**FINAL
DRAINAGE PLAN AND REPORT**

A PROPOSED CHURCH AT 10695 LINDBERGH ROAD

PPR-20-048

December 15, 2020

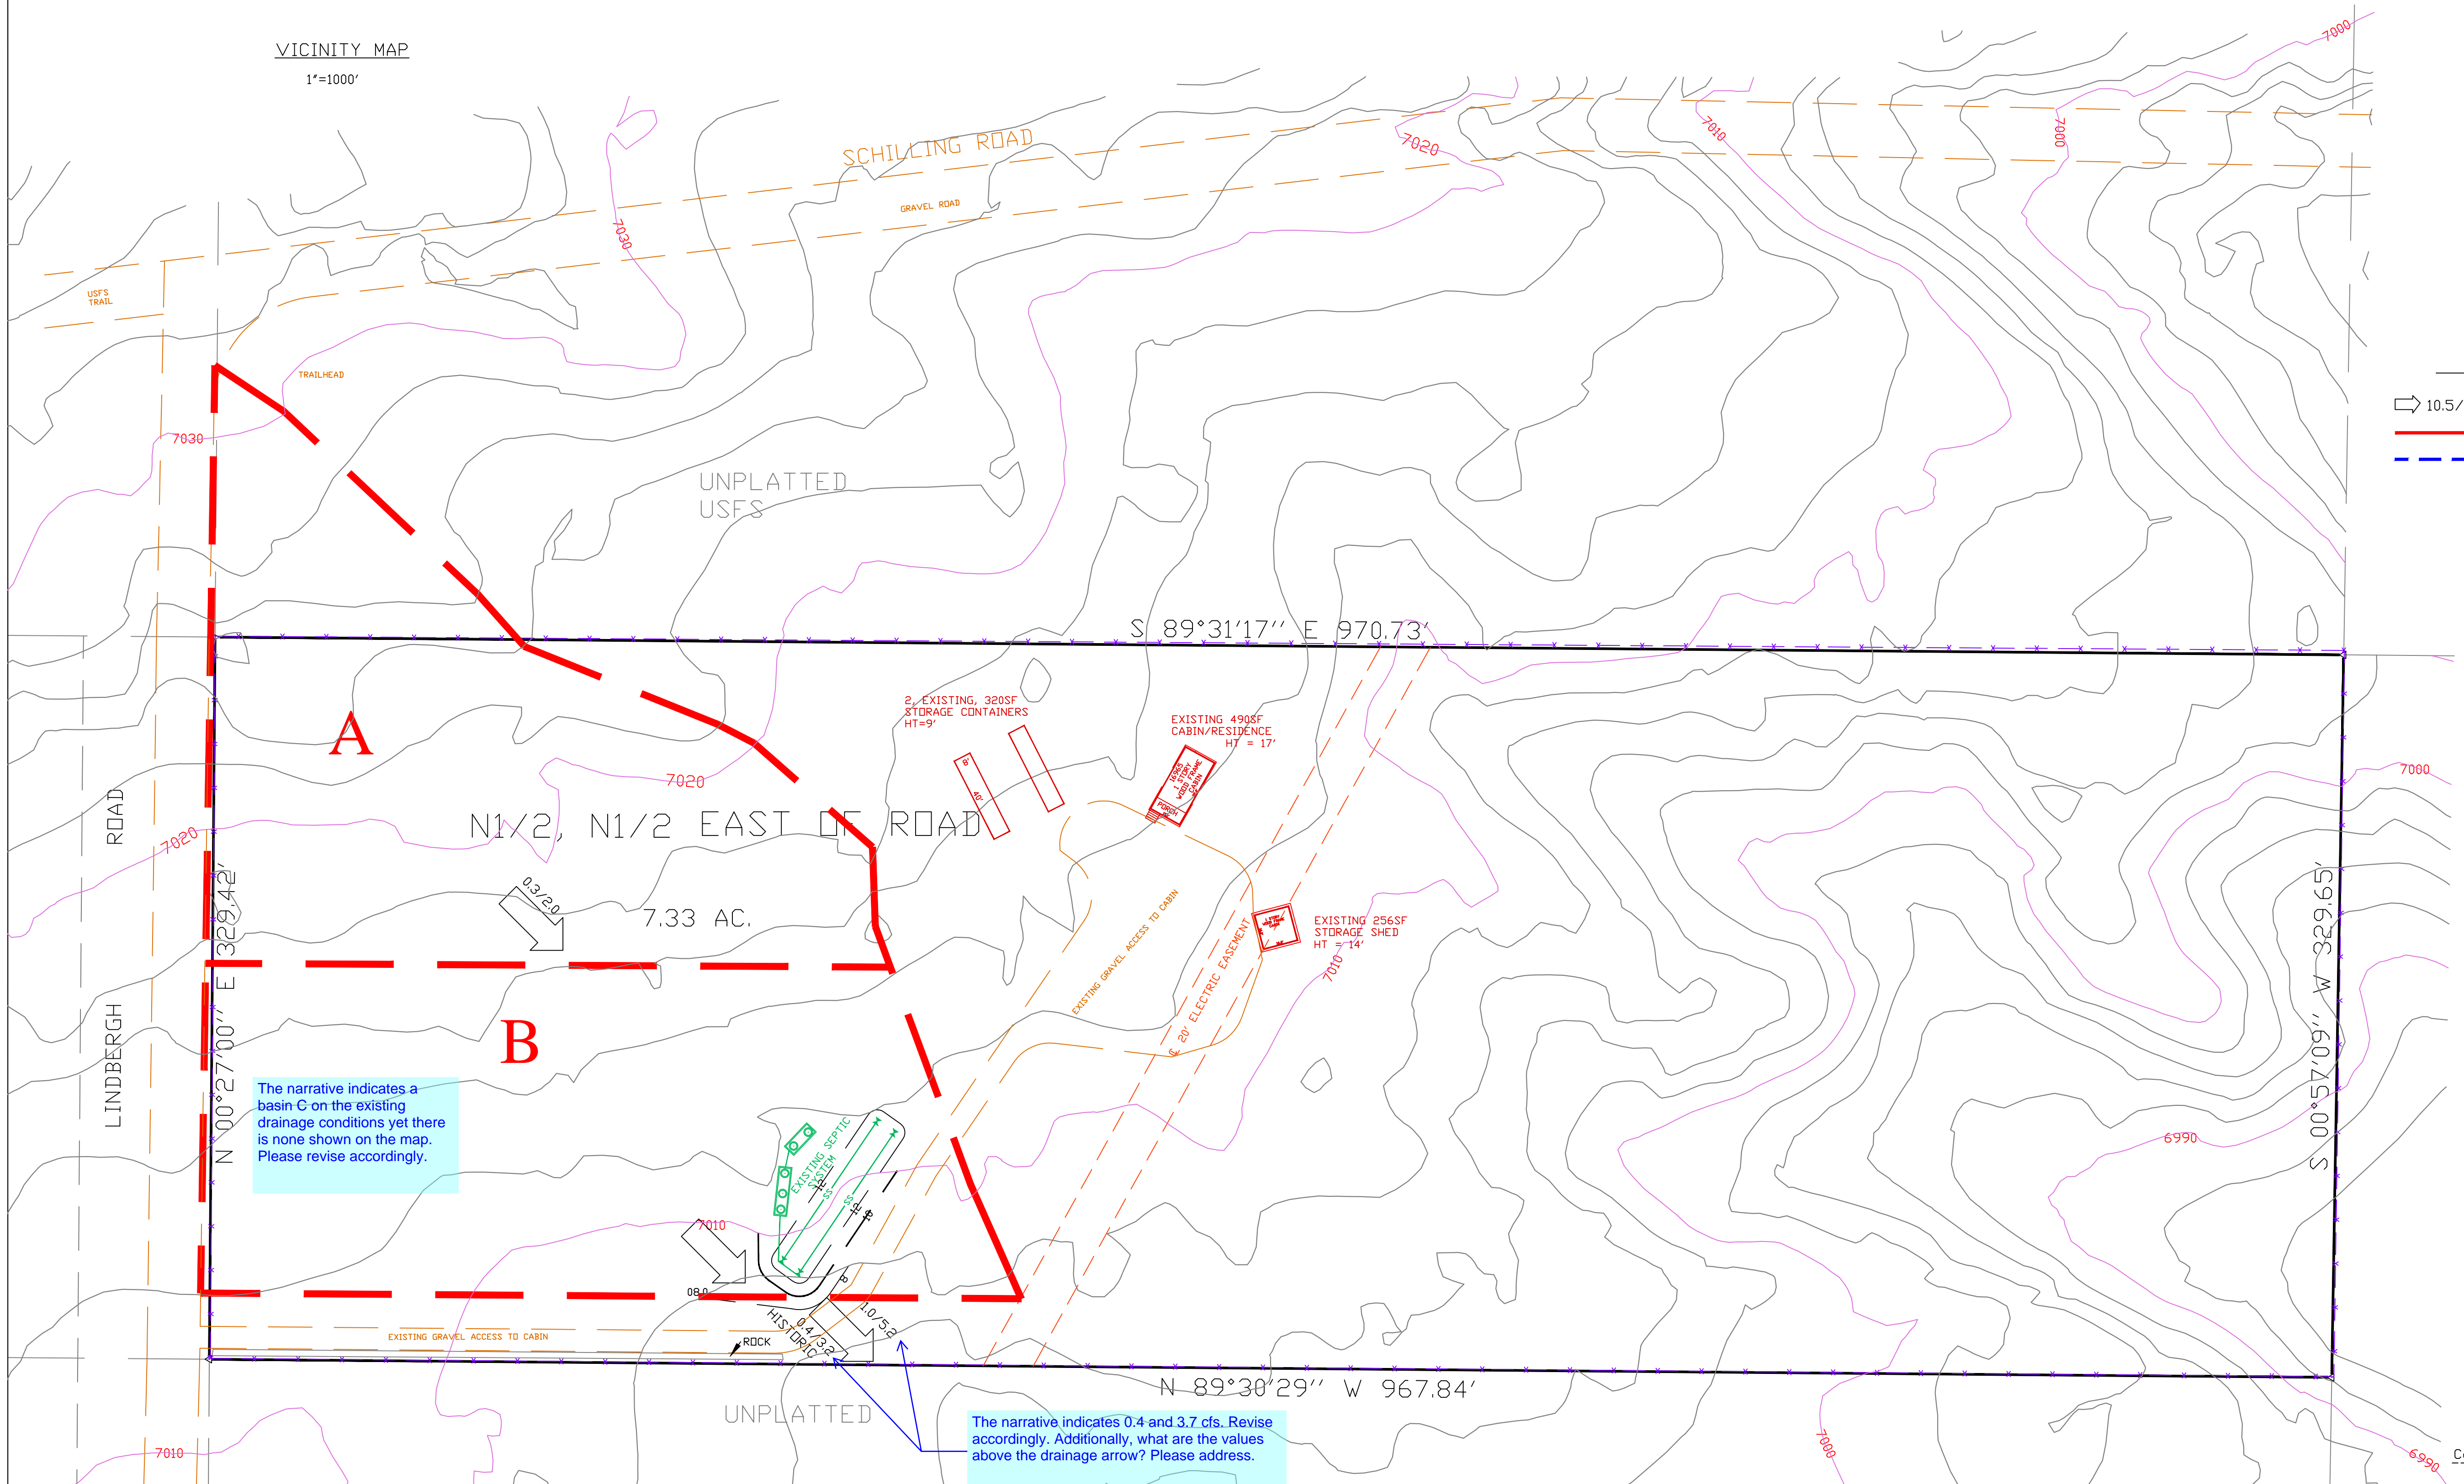
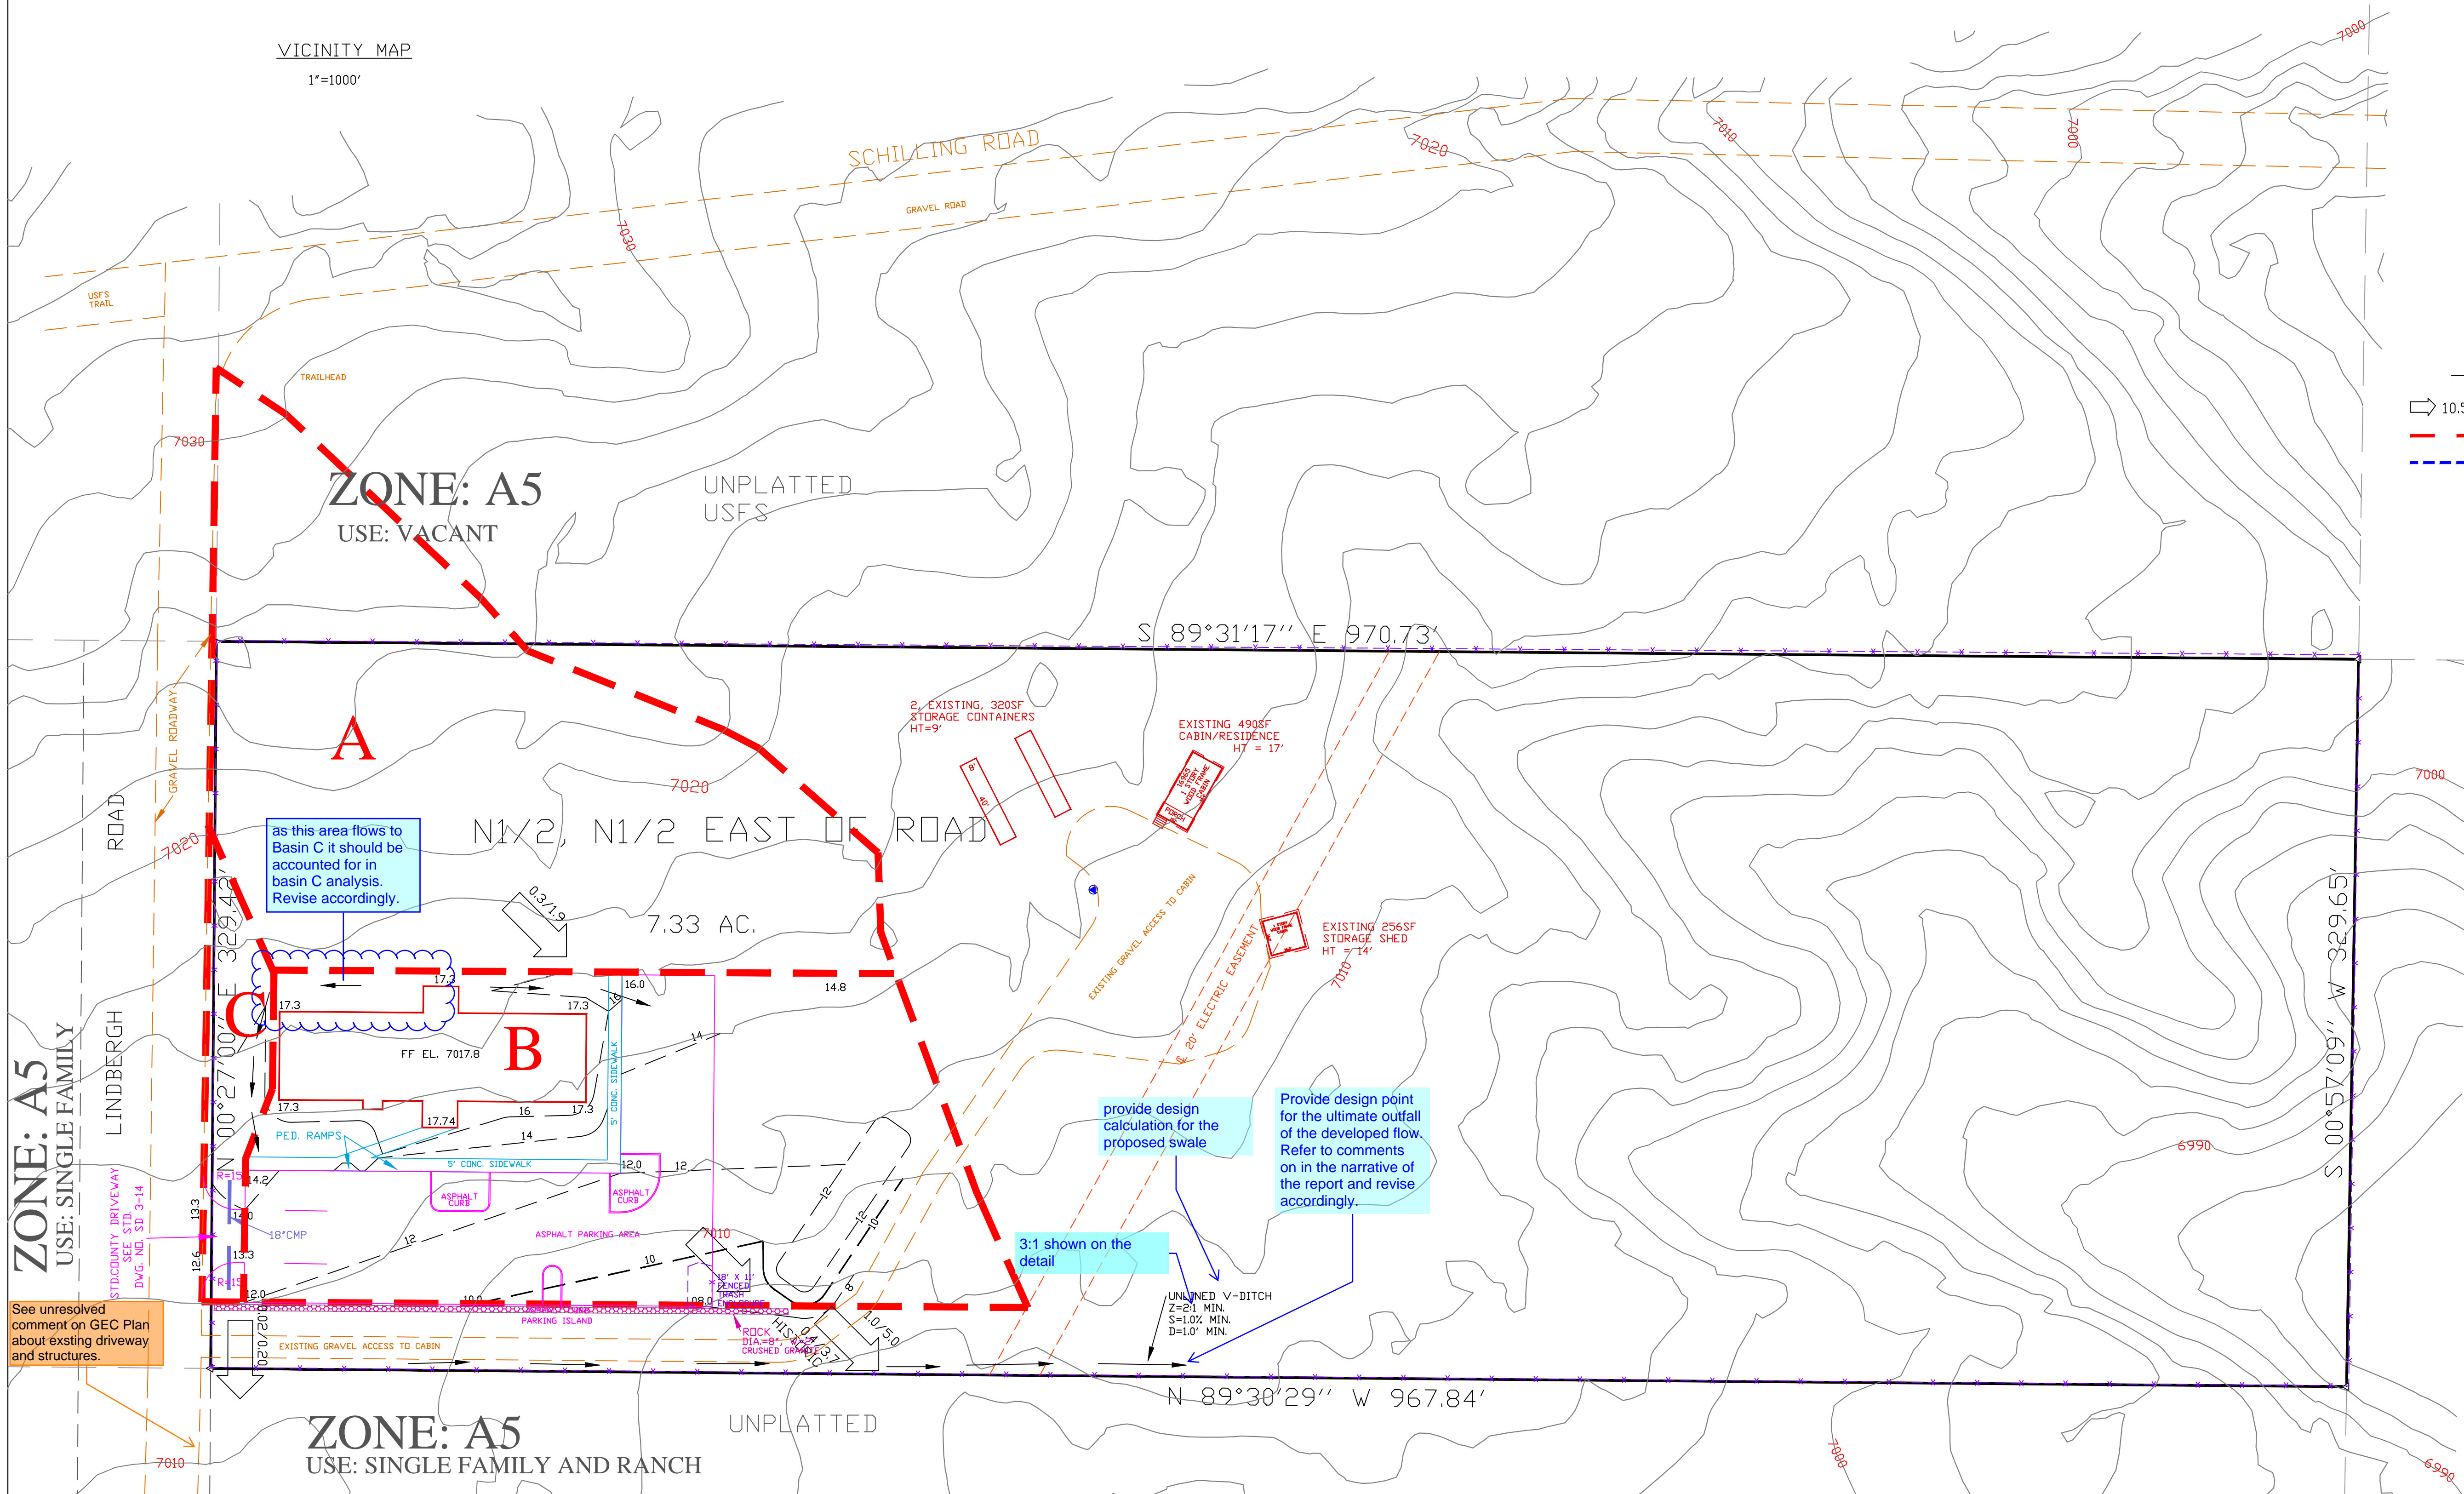
Increases from the historical flowrates is allowable per DCM Vol 1, Chap 2.5.3 if you describe in greater detail how the flow increase will be accommodated downstream. Show some calcs

Please show neighbor's driveway and their existing barn and house for clarity.
